Engineers Comments Regarding Surface Water Drainage

Application Reference:	A/30/26/PL	Reviewer Reference:	ADC/EXT5/AF
Planning Officer:	Kathryn Welch	Date of Review:	06/05/2026
Site Name:	Highdown Garden Centre Littlehampton Road Ferring BN12 6PG		
Application Description:	Demolition of existing open sided structures and erection of retail canopies and restaurant lobby. This application is in CIL Zone 3 (Zero Rated) as other development.		
Assessment Number:	2

Drawing No: A9803 - 140 P2

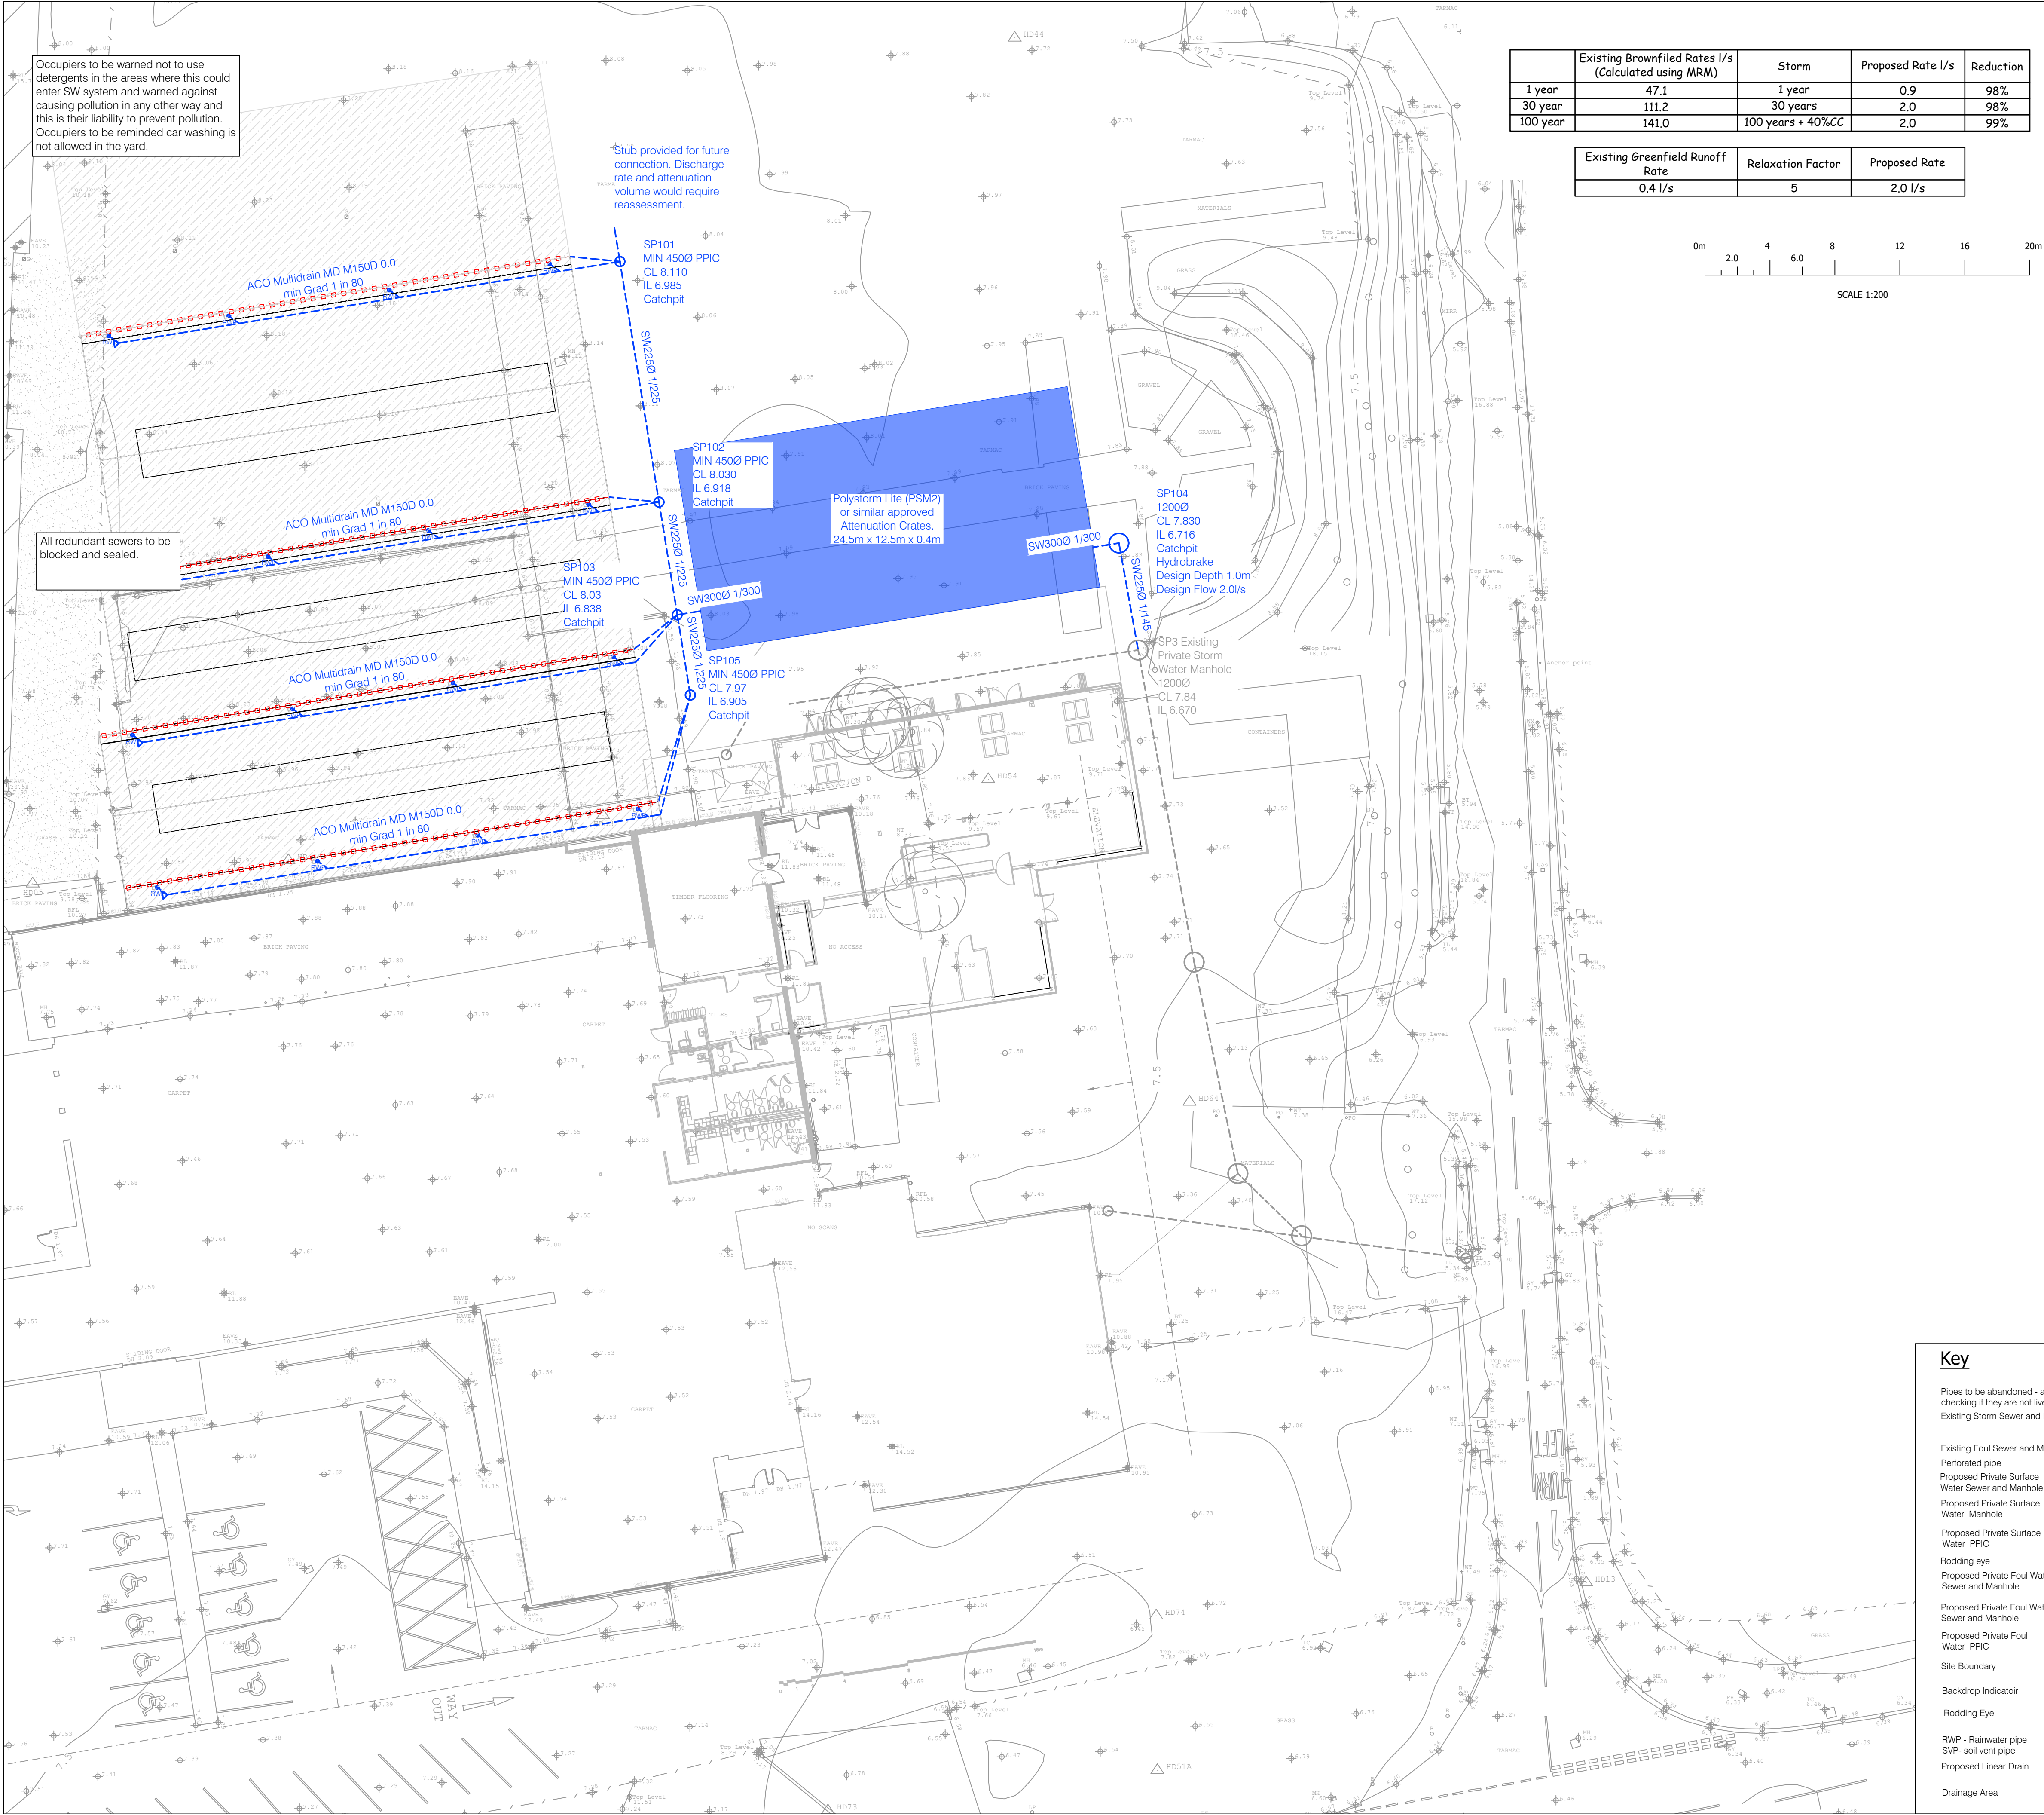
- 0.4. The Drainage Strategy email dated 30 March does not meet ADC guidance, further comments in the subheadings below. The Drainage Layout (A9803 - 140 P0) which contains some information but does not meet our standards for presentation and assessment of sustainable drainage. A Drainage statement should be submitted following guidance on ADC webpages - <https://www.arun.gov.uk/surfacewater>.

- 1.1. The proposed drainage layout shows a piped restricted outlet to the existing drainage system at the site. The downstream outfall is unclear but there is a piped ordinary watercourse shown on our records in the location.

- 1.2. There will be a significant irrigation demand at the site and collection of rainwater for reuse is a higher priority than discharge to piped surface water drainage system. Rainwater harvesting should be incorporated into the design in accordance with NSfS Standard 1.

- 1.3. The submission does not currently provide evidence of the ground conditions described in the drainage strategy email. Infiltration to ground is a higher priority than discharge to piped surface water drainage system. Evidence should be provided that infiltration to ground would not be suitable based upon either low infiltration rates or high groundwater. This may be based upon reliable local geology information and/or information in the public domain on adjacent sites, or new ground investigation.

- 2.1. Interception drainage is not currently incorporated into the design.
- 2.2. Evidence has not been provided to justify the lack of interception drainage provided as part of the sustainable drainage design. Interception drainage is not currently in accordance with the requirements of the NSfS Standard 2. Therefore, we **object** to the application.

- 3.1. The calculations provided are not in accordance with ADC criteria. The latest rainfall profiles are not used, CV values are low, the peak outflow is not related to greenfield runoff.

- 4.1. Water quality mitigation is not currently incorporated into the design.
- 4.2. The runoff should be assessed against the Simple Index Approach within the SuDS Manual or similar method. There is no trafficked areas shown on the layout and measures to mitigate runoff from roof areas and paths are likely to be able to be integrated at technical design stage.
